An
Bord
Pleanála

Inspector's Report

ABP-322078-25

Development	Proposed development of a 110kV electricity substation and approximately 8.8km of underground electricity line.
Location	Located at Shankill and Ballygorteen, County Kilkenny and Lacken, Moanmore and Baunreagh, County Carlow.
Planning Authority	Carlow County Council Kilkenny County Council
Applicant(s)	White Hill Wind Limited
Type of Application	Application for approval under section 182A of the Planning and Development Act, 2000 as amended.
Prescribed Bodies	Kilkenny County Council Carlow County Council Inland Fisheries Ireland Development Applications Unit Uisce Eireann

FIGURE 7.04: TYPICAL ELECTRICITY LINE TRENCH DETAIL

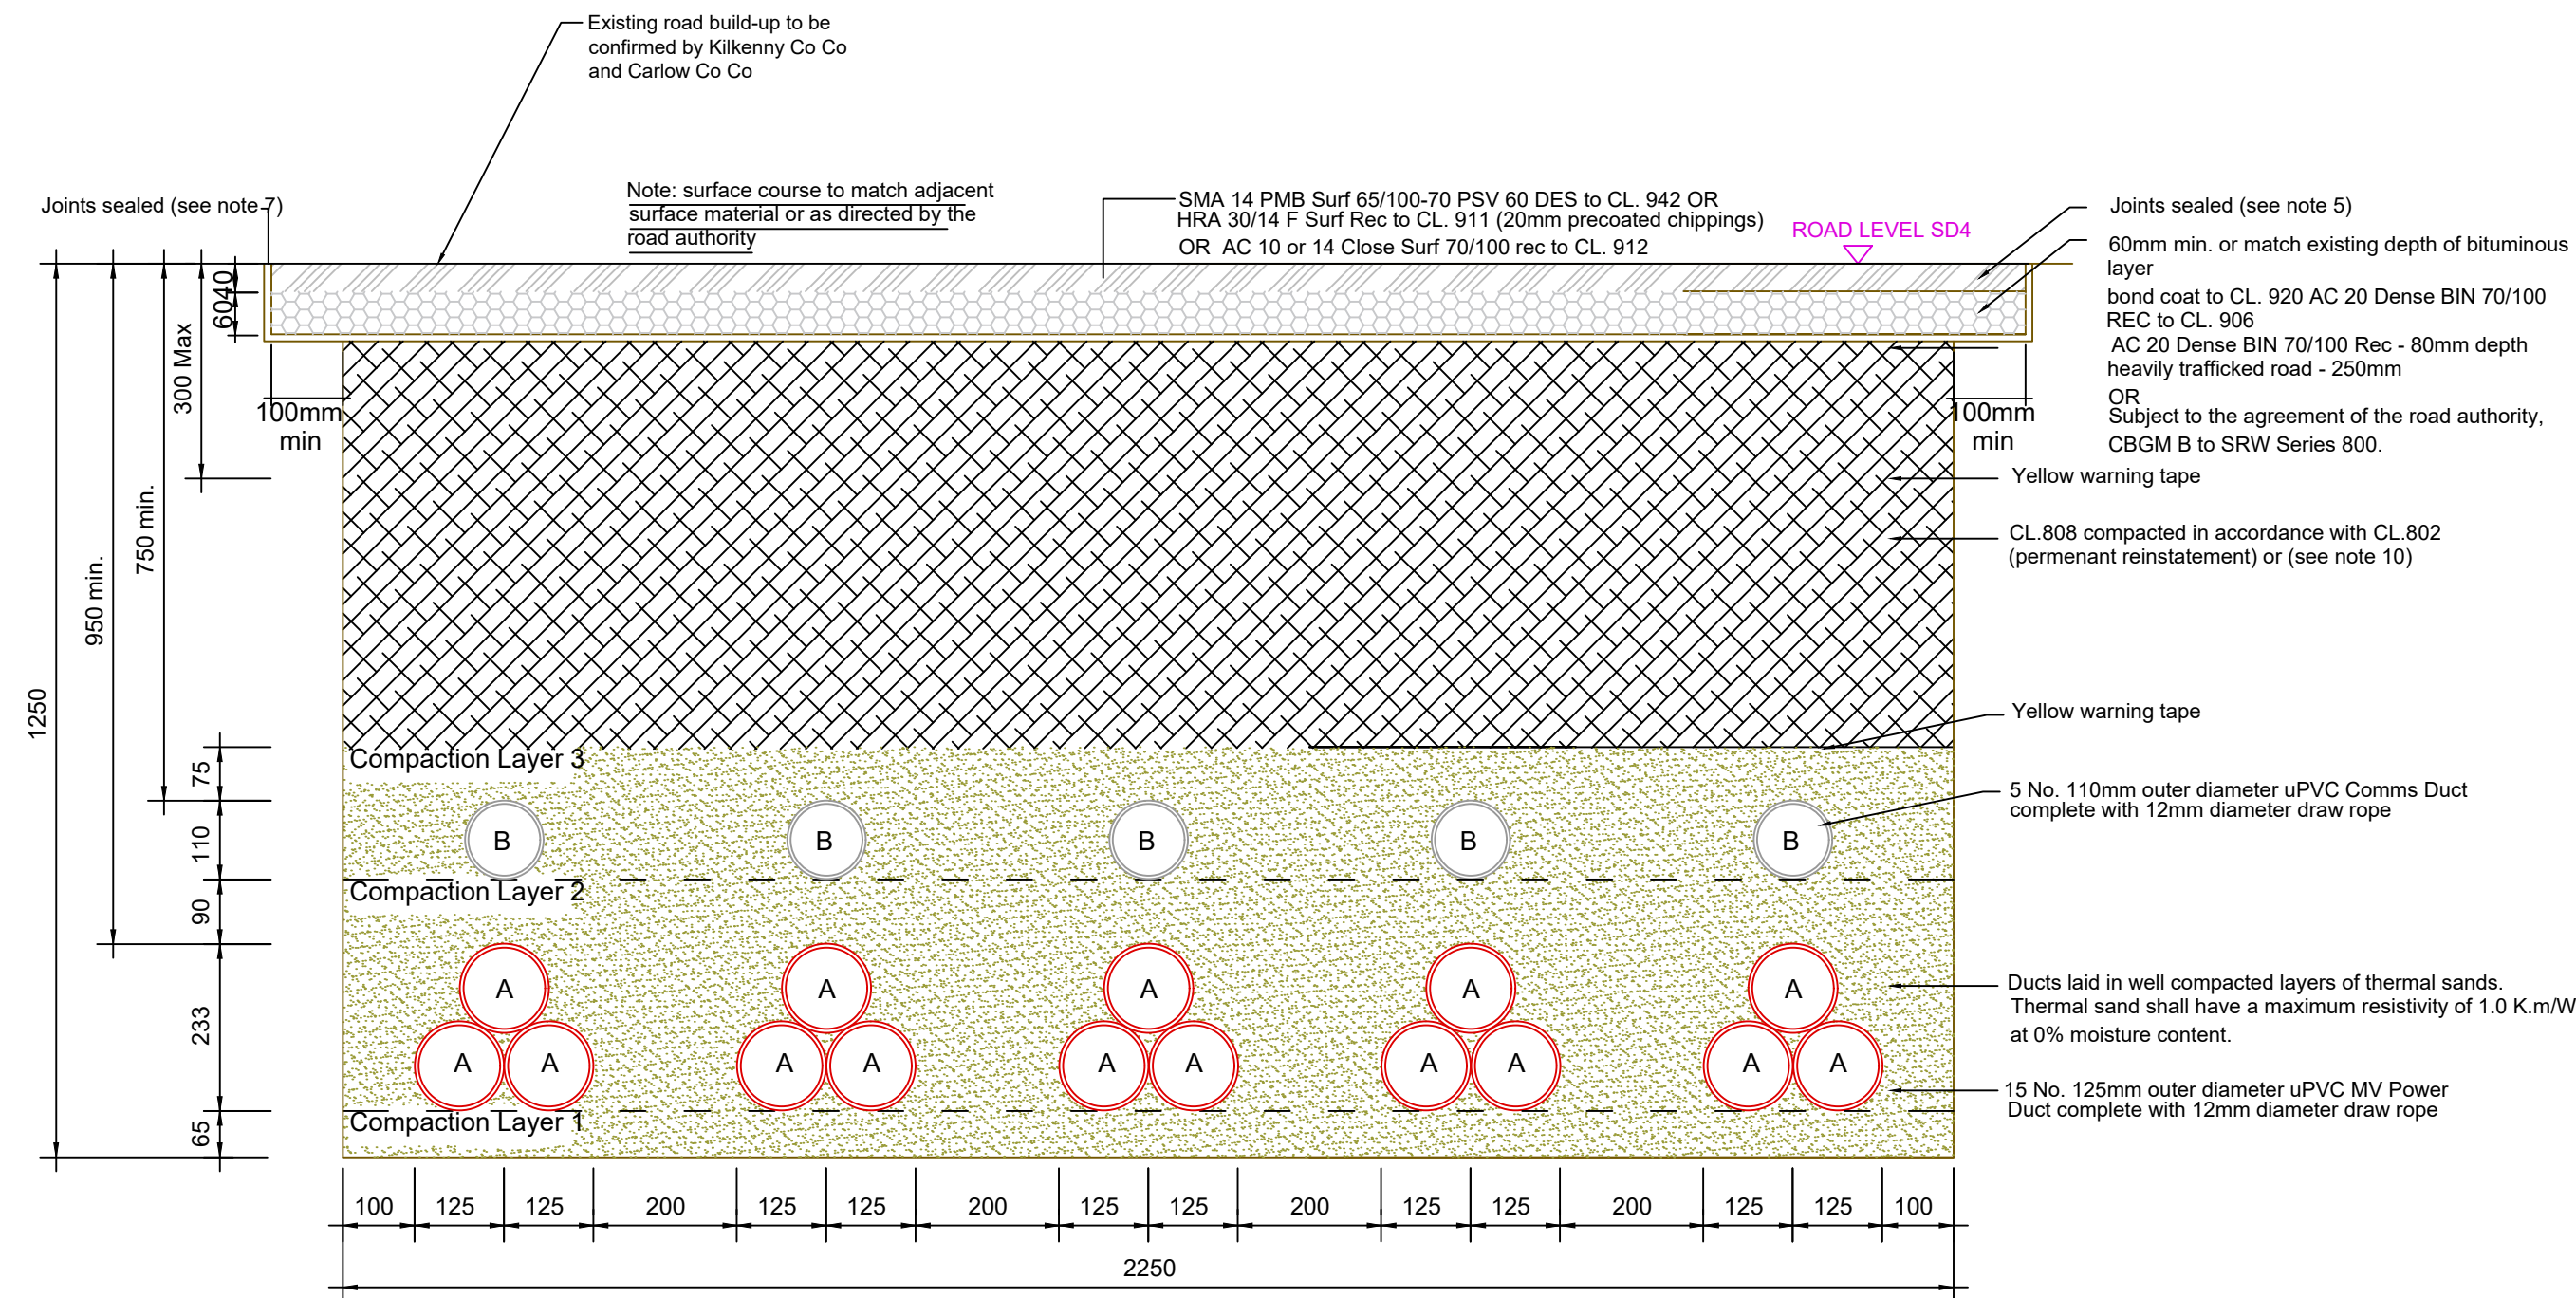
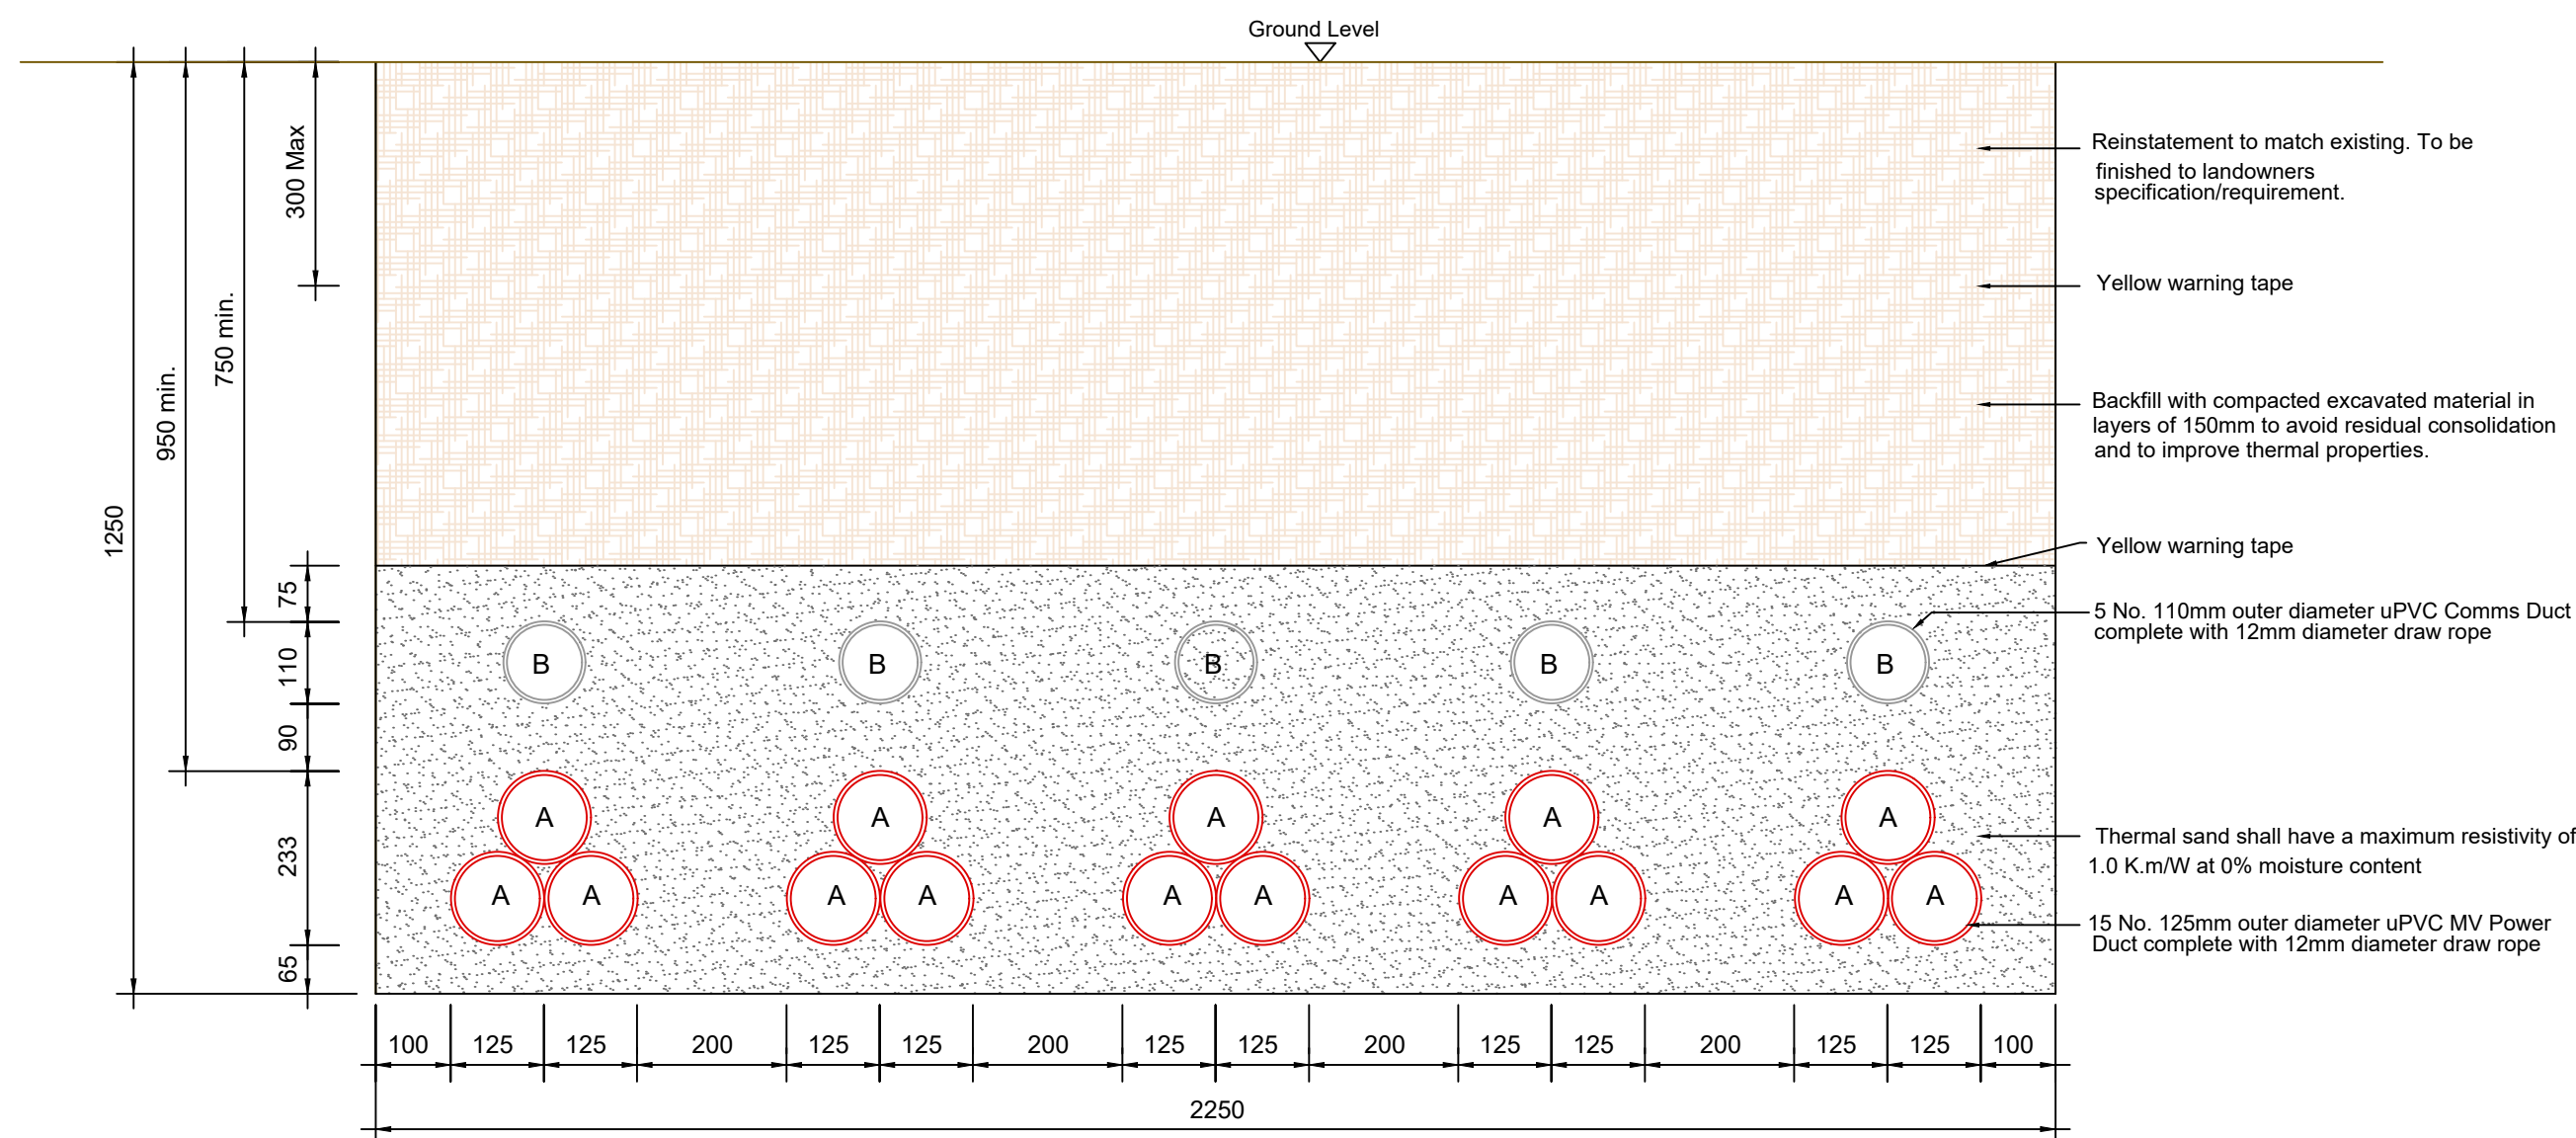
- Concern is raised in terms of the vertical clearance from the road surface to the proposed ducting with respect to trench detail as well as potential joint pit chambers located in the public road. The construction details provided potentially limits the clearance for the installation of other services, drainage improvements and maintenance. Revised typical trenching details are required subject to consultation with Kilkenny County Council.

- Reference is made to the Interim Guidance to Road Authorities regarding the proposed placement of medium or high voltage electricity assets under public roads (DoT, Circular RW07 of 2025, dated 14th March, 2025) indicates that the depth of cover to the Transmission HV cable ducts should be no less than 950mm.

- Due to the width of the public road, full road reconstruction may be required to the bottom level of the trench over the full carriageway. A full assessment will be required.
